App No: Y/20/18/OUT

Address: Land adjacent to Bonhams & Flints Hoe Lane Flansham PO22 8NP

Proposal: Outline application with some matters reserved for the erection of 10 dwellings with access from Hoe Lane, Flansham (resubmission following Y/40/17/OUT).
This application is a Departure from the Development Plan.

Updated bat comments

1. EXPLANATORY SHEETS, TREE INSPECTION SHEETS
2. TREE CONSTRAINTS PLAN, DRAWING NO. J53.95/01 Rev. A
3. TABLE OF BS CALCULATED ROOT PROTECTION AREAS (RPAs)

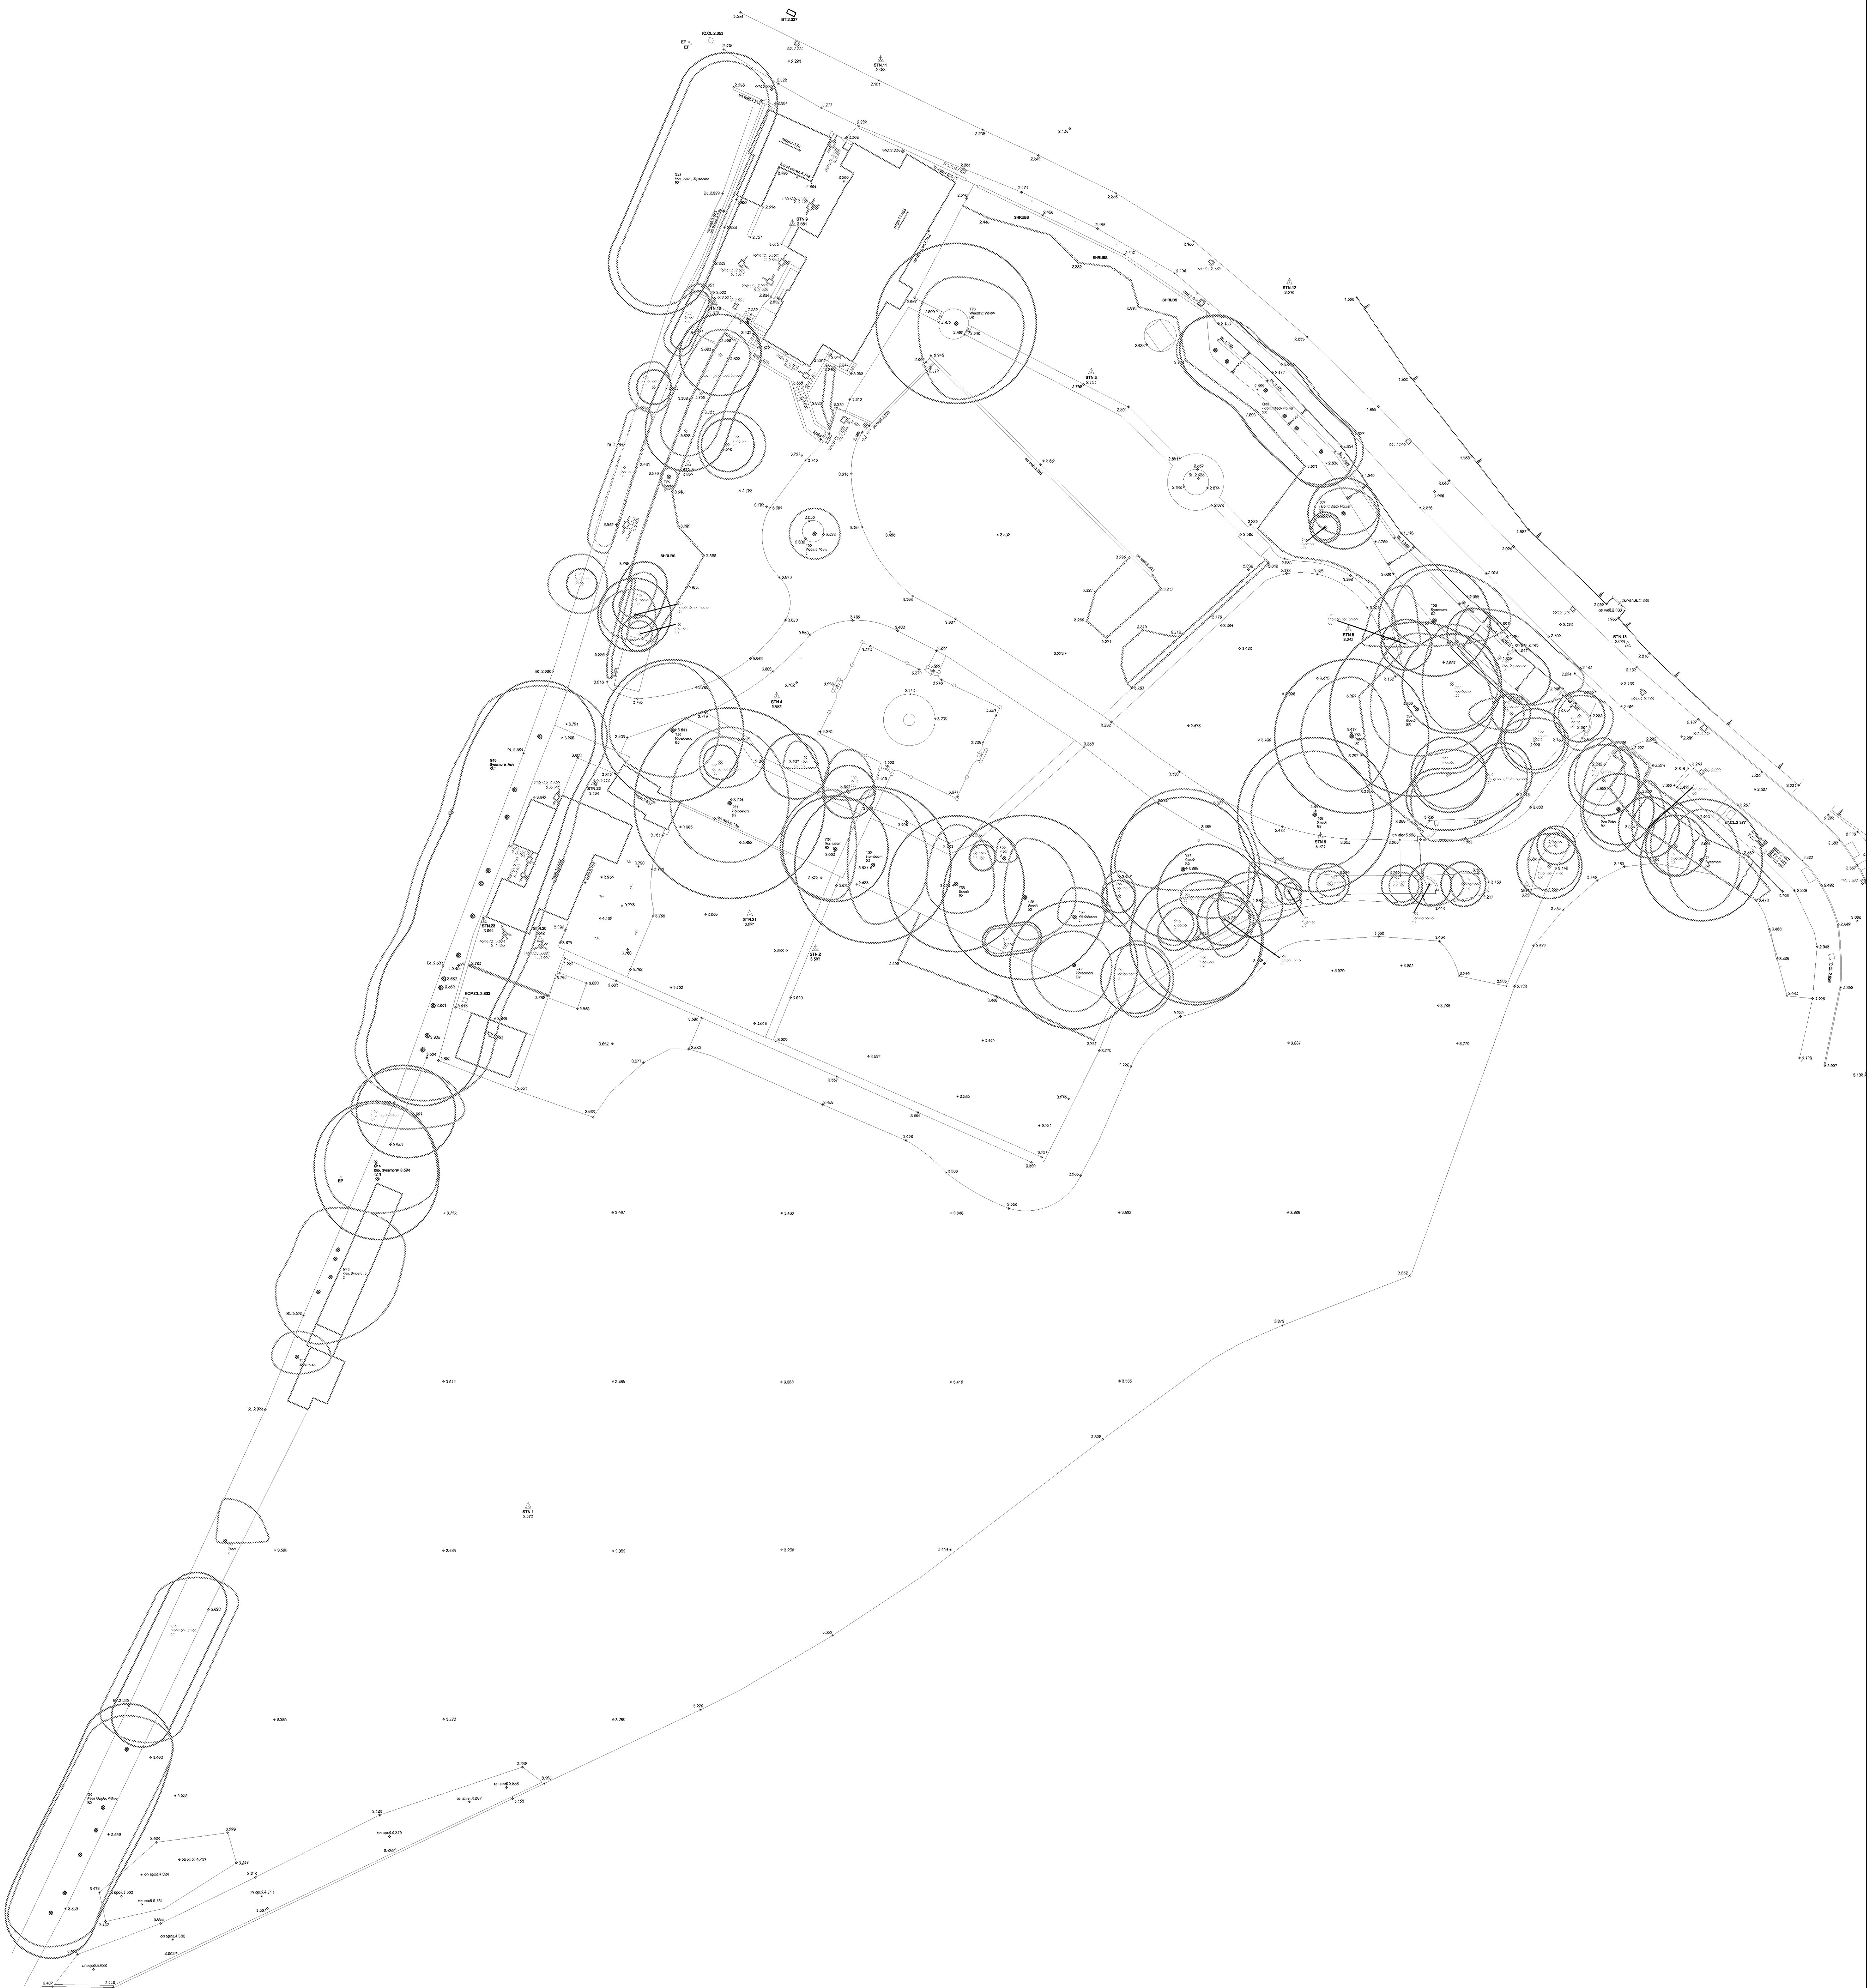
Following submission of the bat survey it was been determined that the beech tree (T470 onsite supports a bat roost and will need to be retained and protected from harm with a 10 m buffer with no light spill within this radius. A condition should be used to ensure this that's place.
